***Residential Development Stage 1 Phase 1
Royal Rehabilitation Centre, Ryde***

MP10_0189 MOD 4

***Design changes to two dwellings and temporary
use of one dwelling as a Sales and Marketing
Suite.***

Secretary's
Environmental Assessment Report
Section 75W of the
Environmental Planning and Assessment Act 1979

GROUND FLOOR PLAN

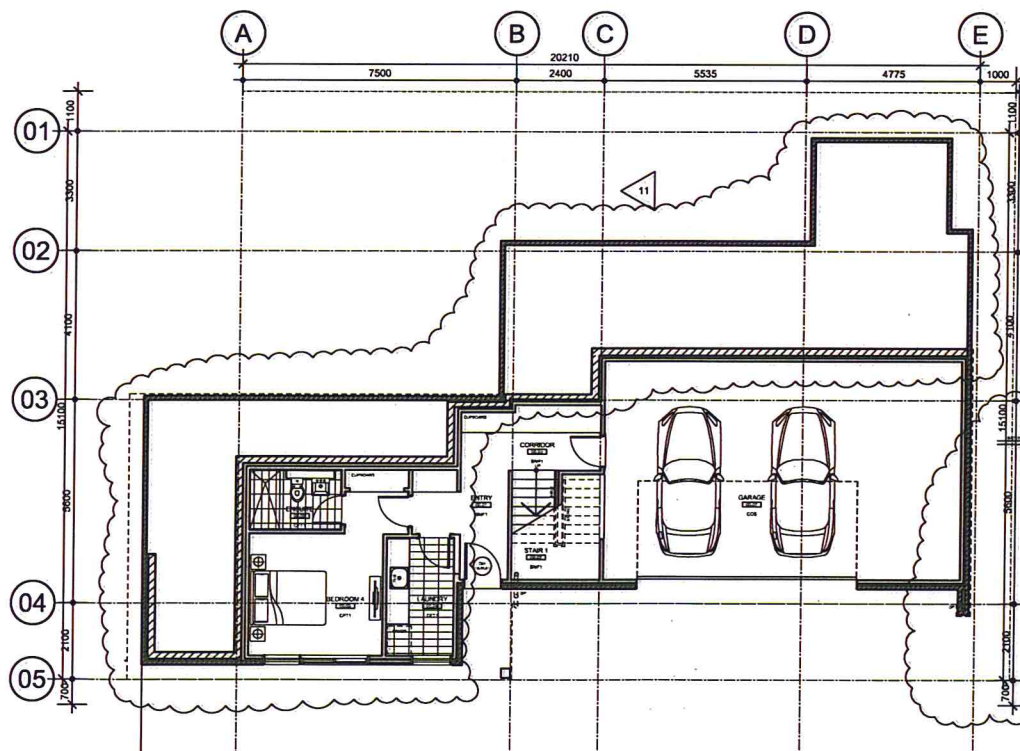
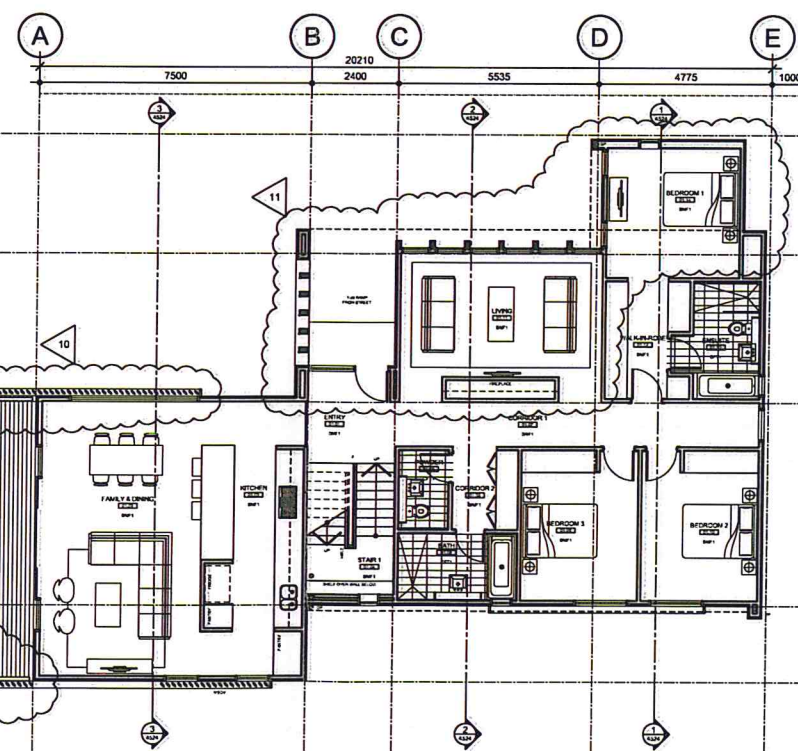
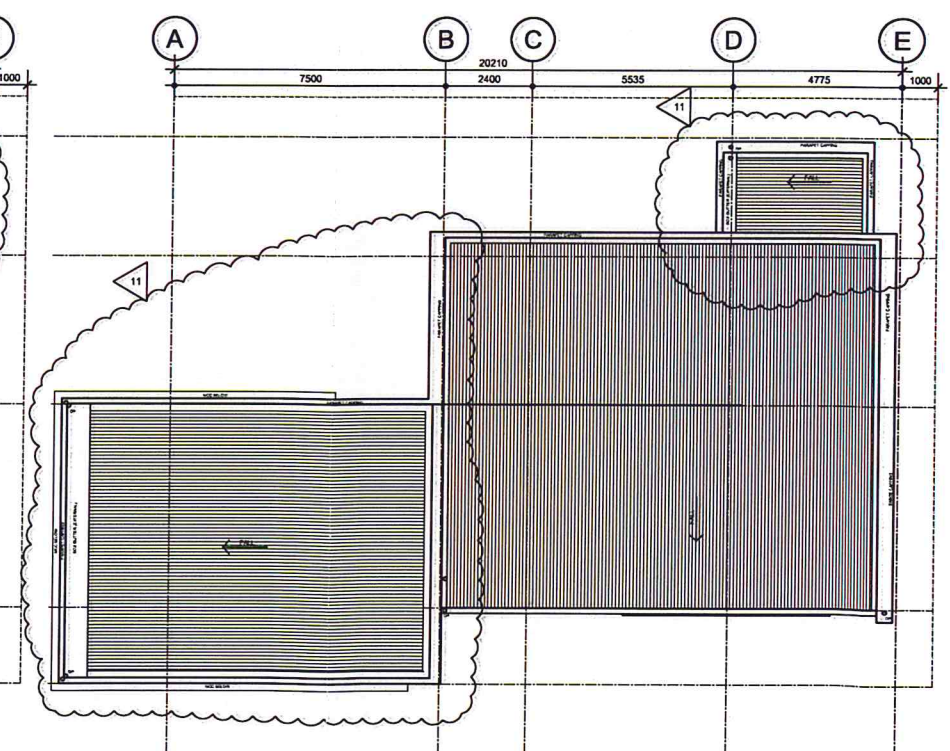
- (b) minor changes to the design of the building on Lot 23 (known as Housing Type 2E) including amendments to the roofline and increase of maximum building height by 0.8m, internal reconfiguration of room layouts, amendment of window locations and sizes, and amendments to external building materials; and

The proposed design changes to the two buildings are minor in nature and are not considered to adversely affect the design quality of the buildings, the internal amenity of the buildings, or the amenity of neighbouring premises.

The minor increase in building height to Lot 23 results in a building which remains below the height limit of 9.5m for this section of the site and is acceptable in the context of adjoining developments. Proposed internal changes are considered to improve the functionality and amenity of the two dwellings.

Drawing Title			
HOUSING TYPE 2J - DETACHED			
Drawing Number	Revision	Date	North
A-PA-FP-H2J1	11	06-05-2014	
Issued for	Scale	Drawn	
SECTION 75W	1:100@A1	ME

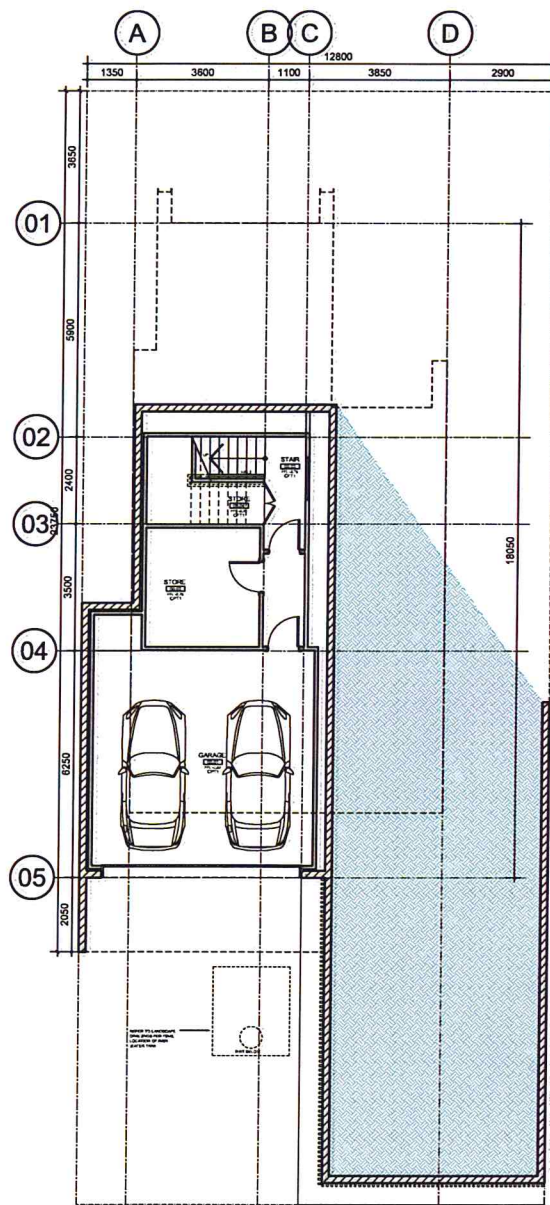
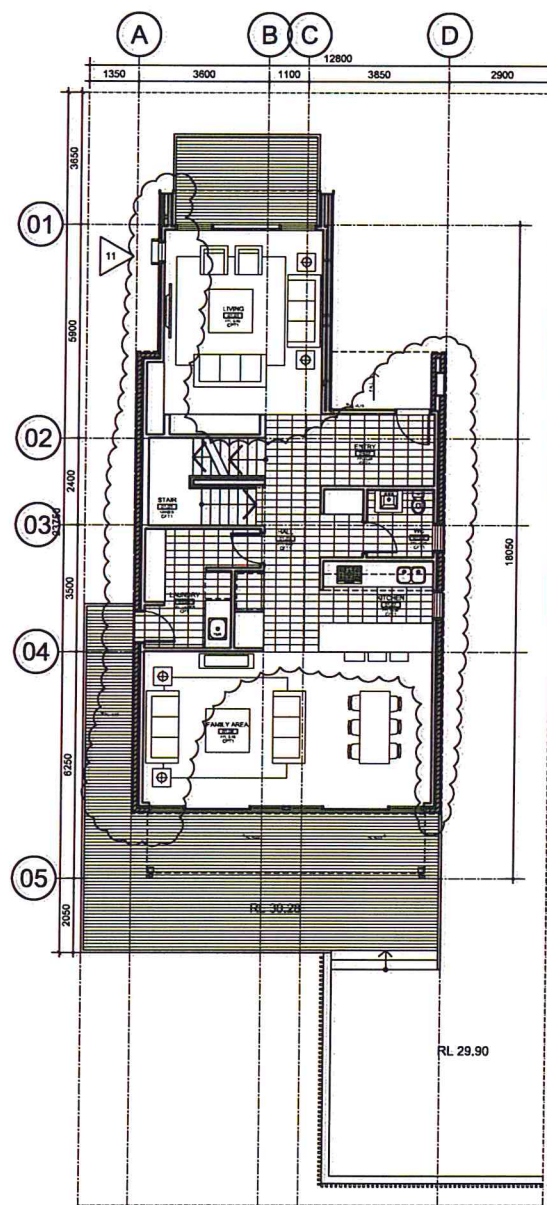
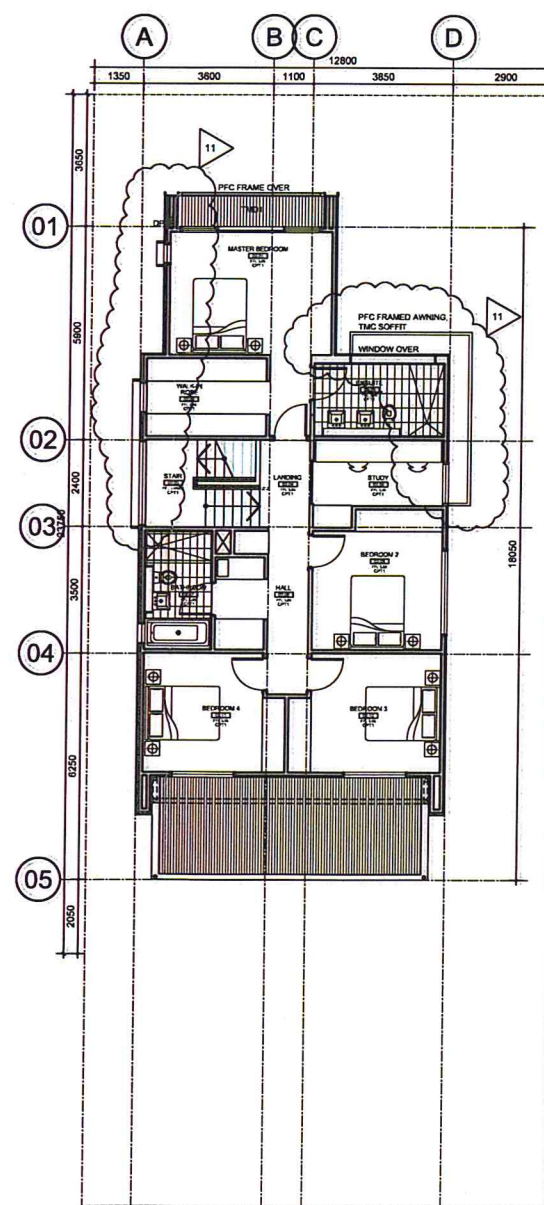
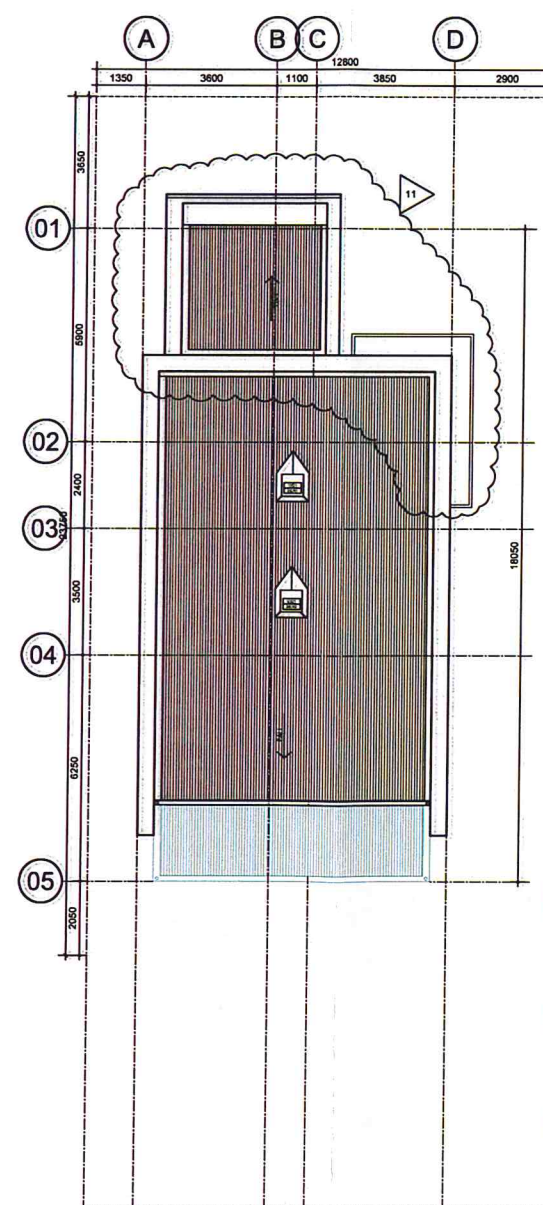
- (c) minor changes to the design of the building on Lot 2 (known as Housing Type 2J) including amendments to the roofline and reduction of maximum building height by 0.6m, internal reconfiguration of room layouts, additional awning element on the north-east corner, amendment to the siting of front section of the building (relocated 0.4m to the north-east) and amendments to external building materials.
